## **Deadline 8 submission**

### **NACP submission on the provision for Non-motorised Users (NMU) along the A5025/A5**

Drawing Title
**A5025 OFF-LINE HIGHWAY IMPROVEMENTS
SECTION 1 - VALLEY
PROPOSED GENERAL
ARRANGEMENT PLAN - SHEET 1**

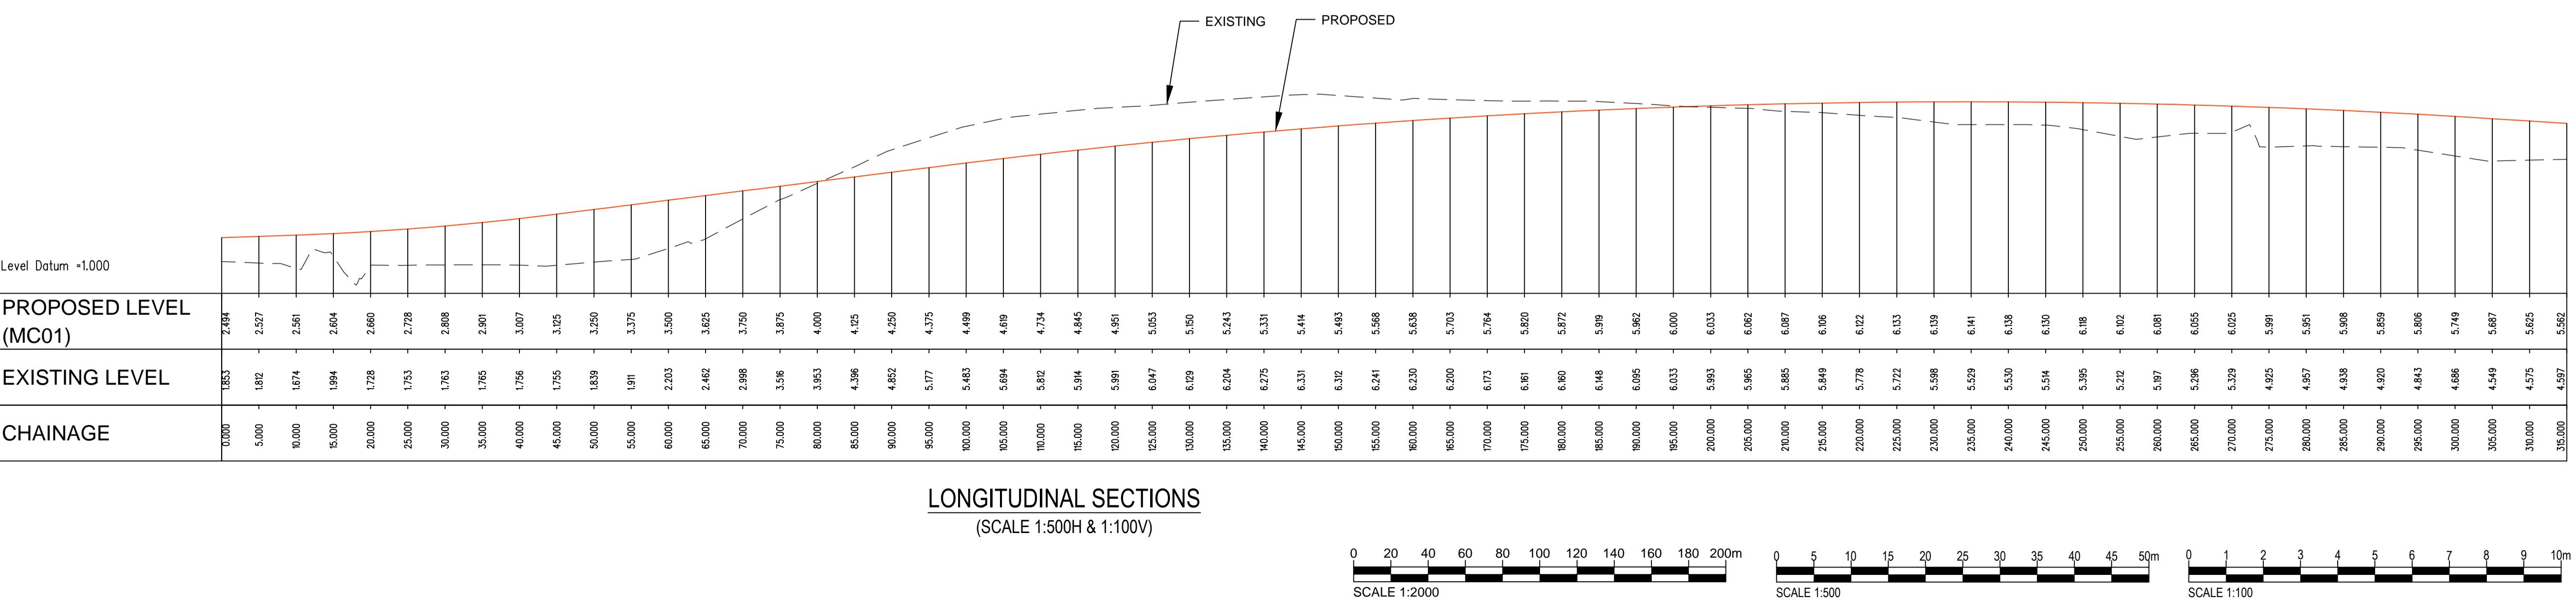
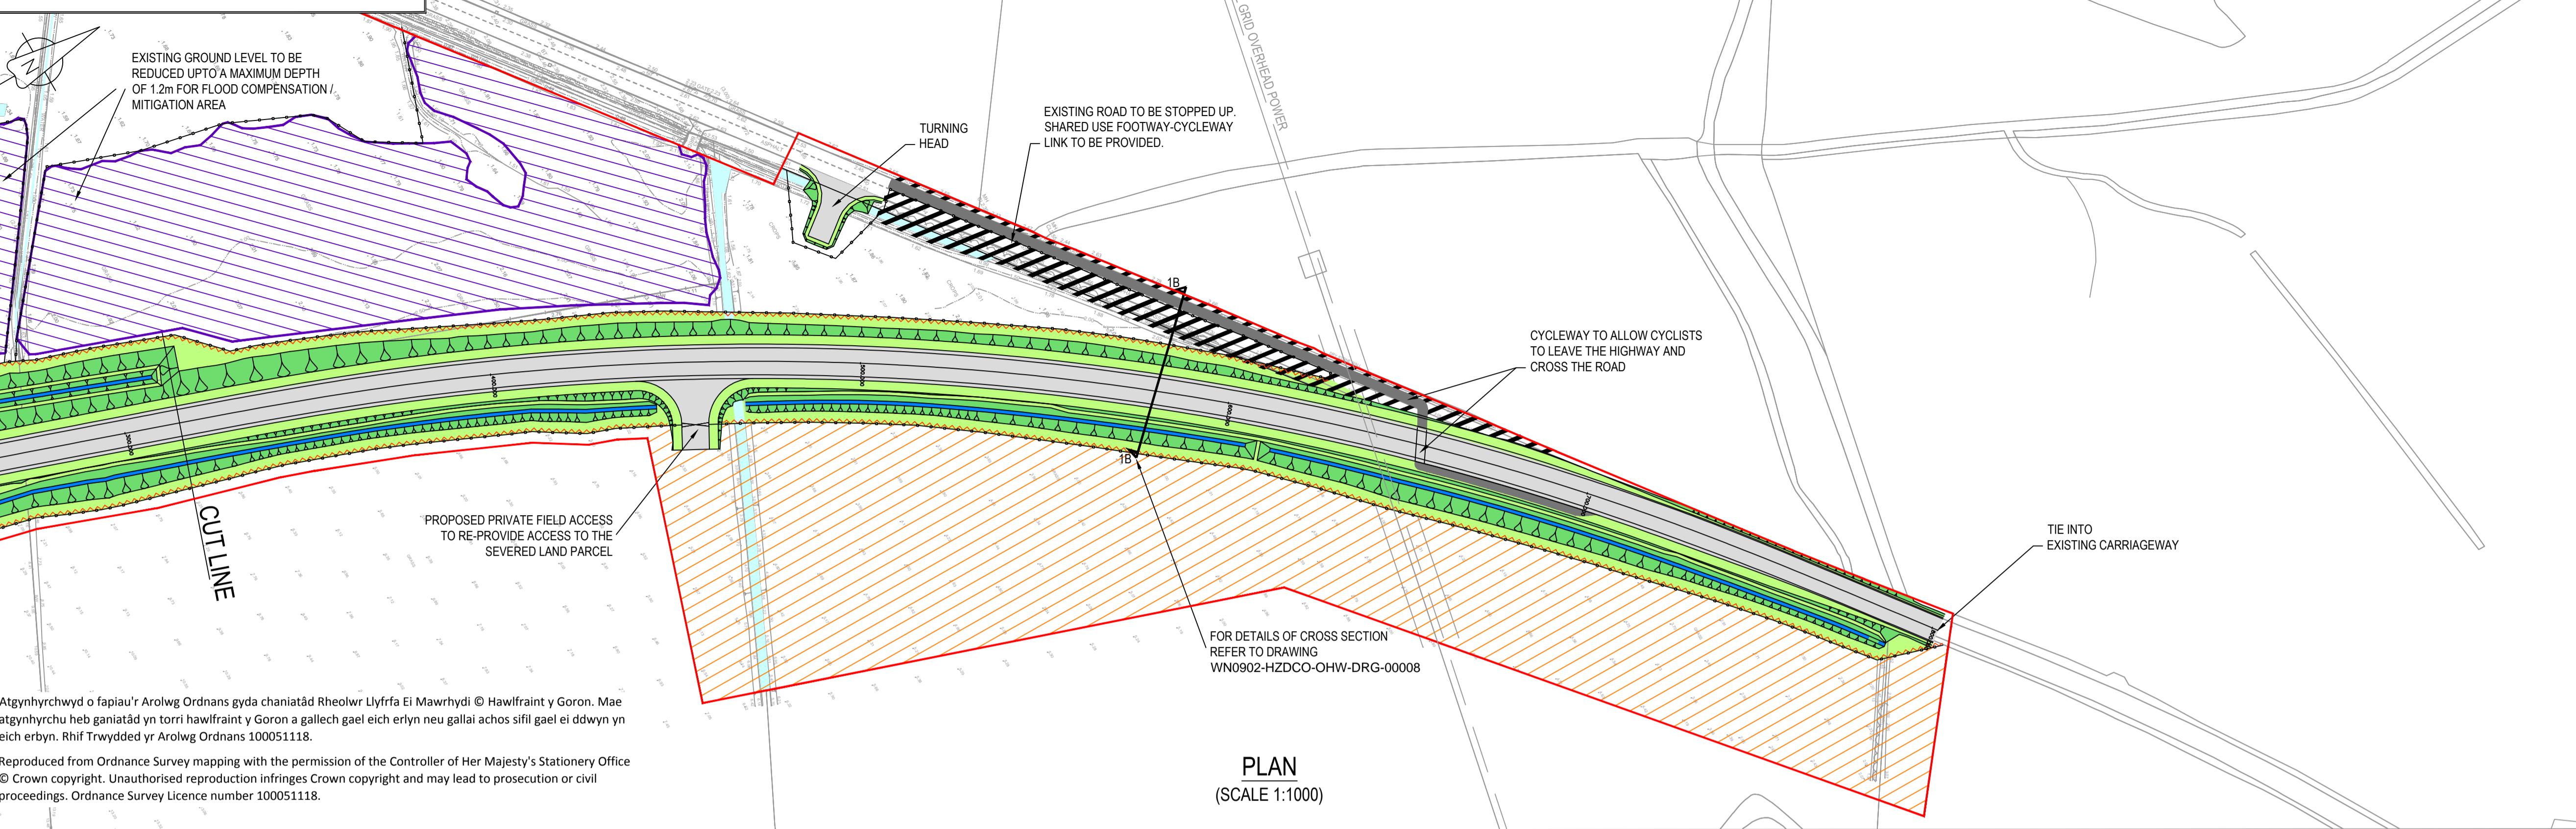
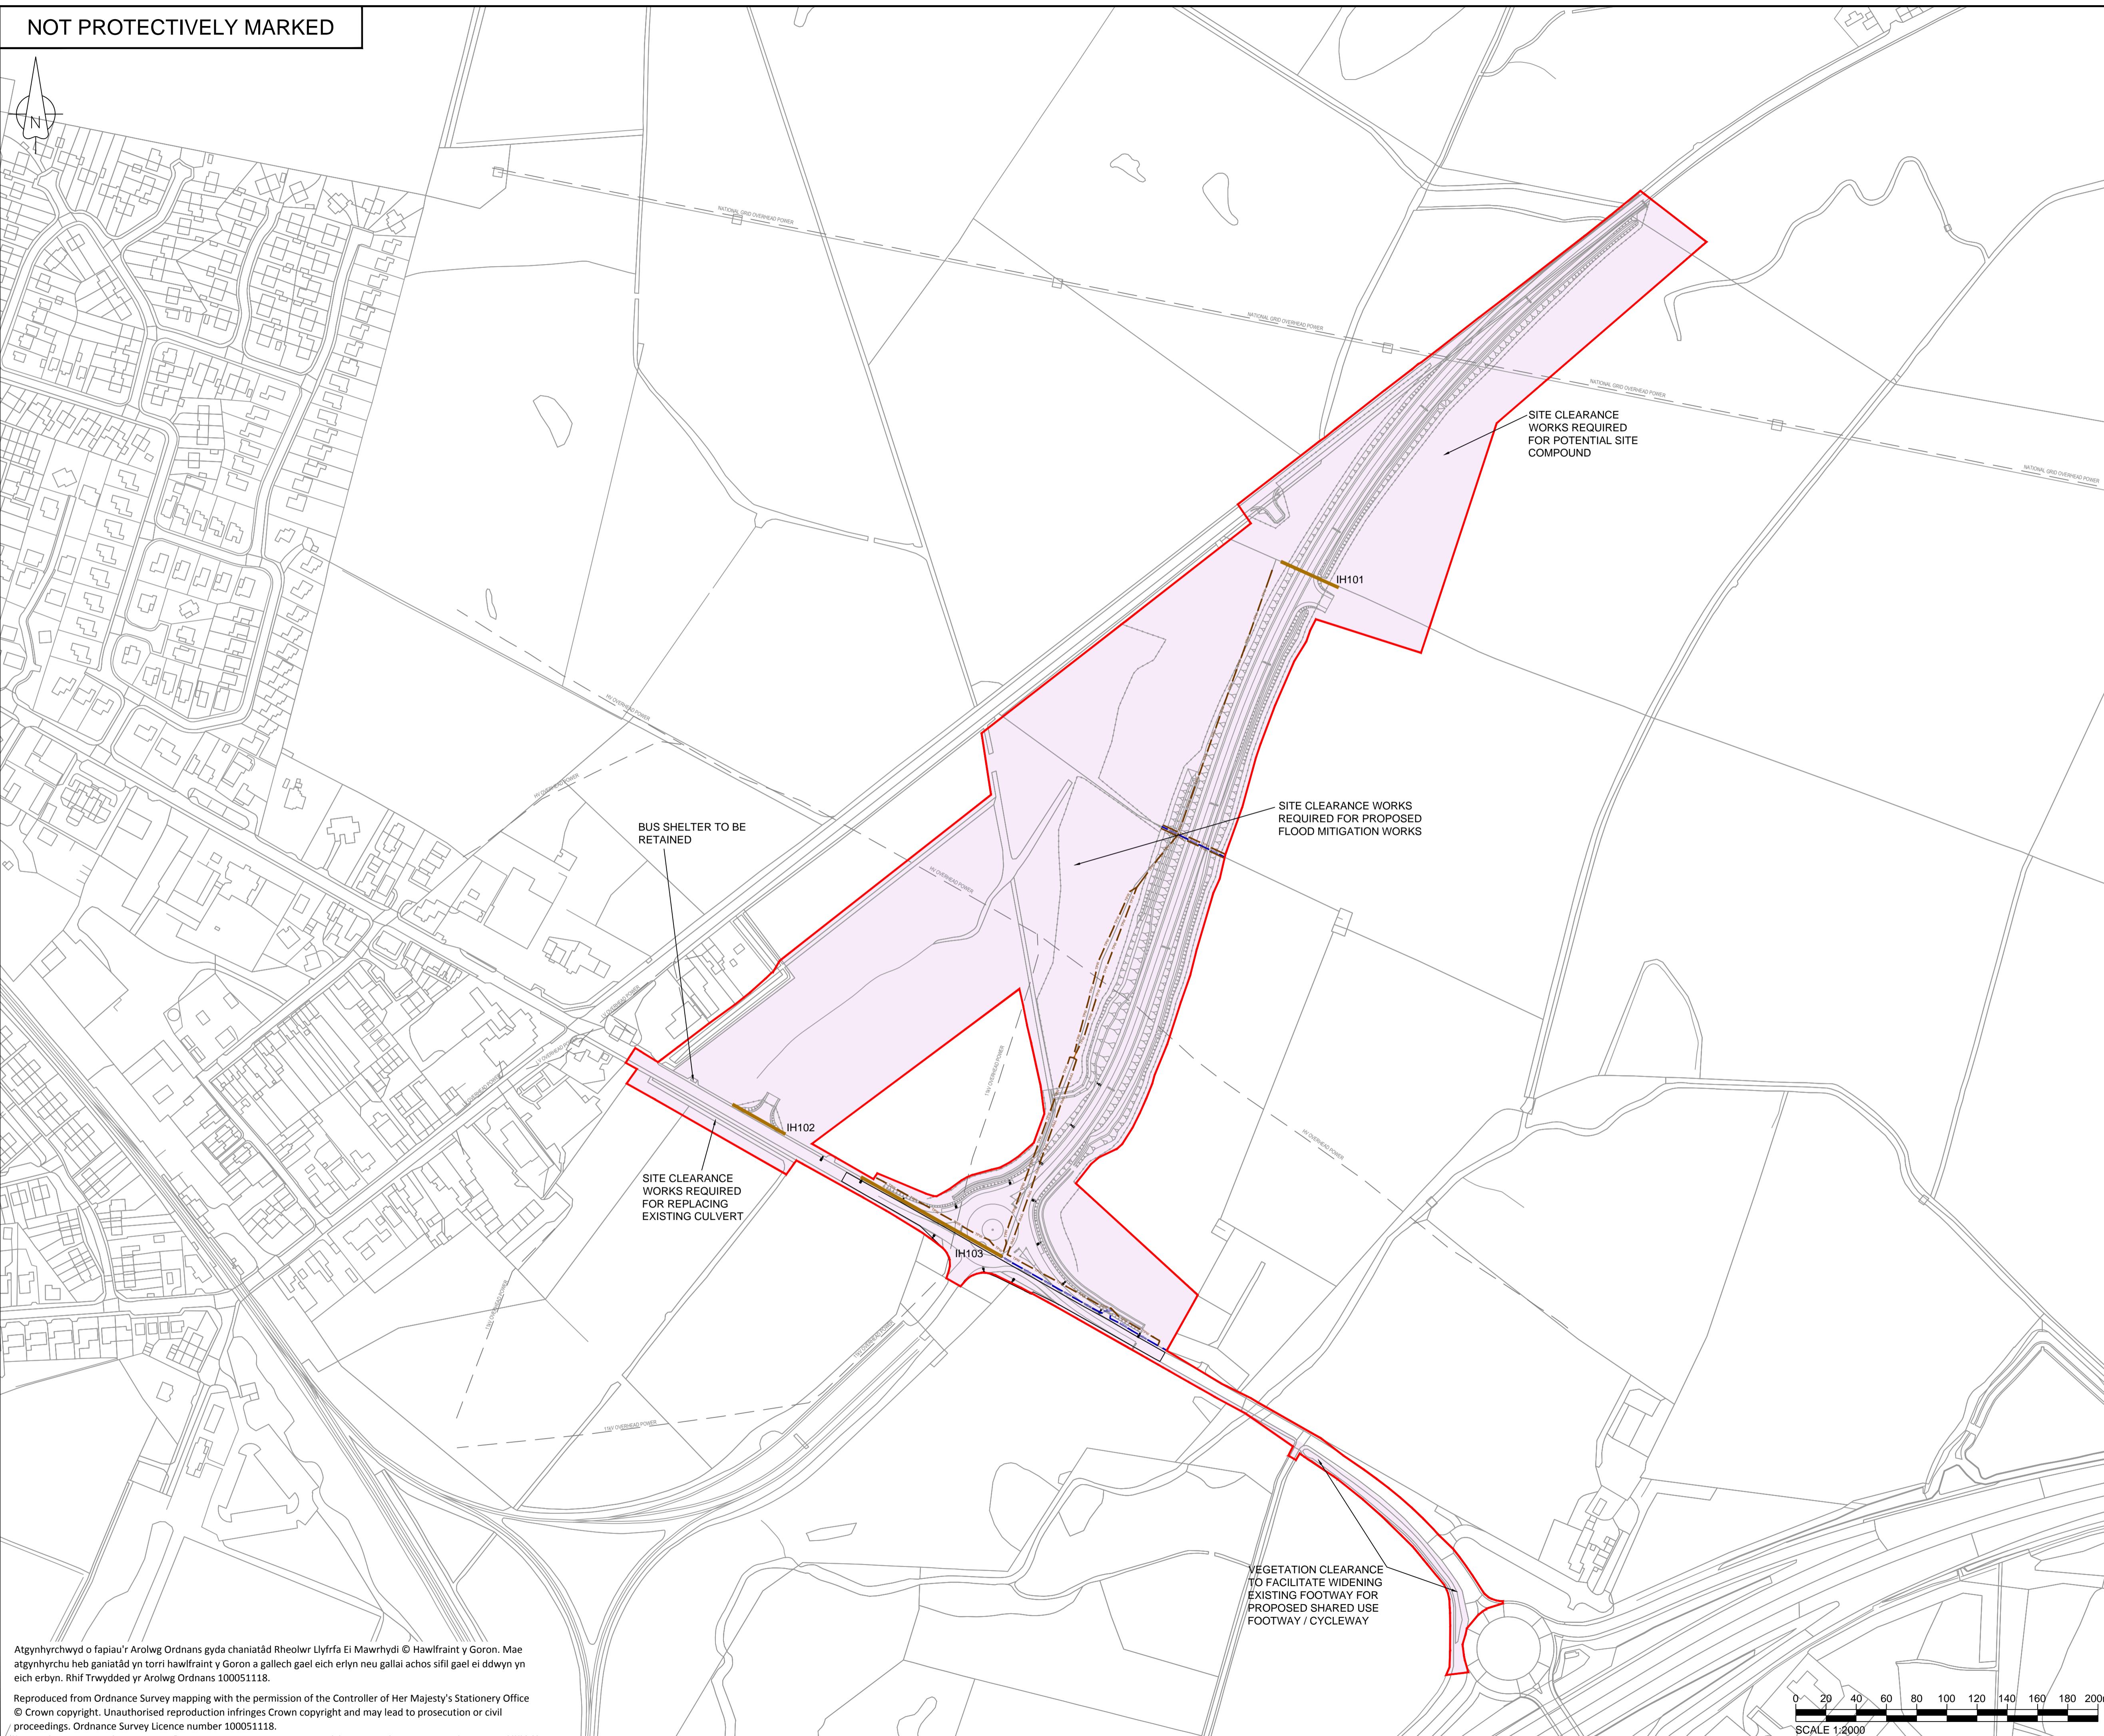
The NACP are broadly supportive of the arrangements discussed for NMU at the Valley traffic light junction. The NACP would wish to be informed of, and involved in, discussions at the detailed design stage.
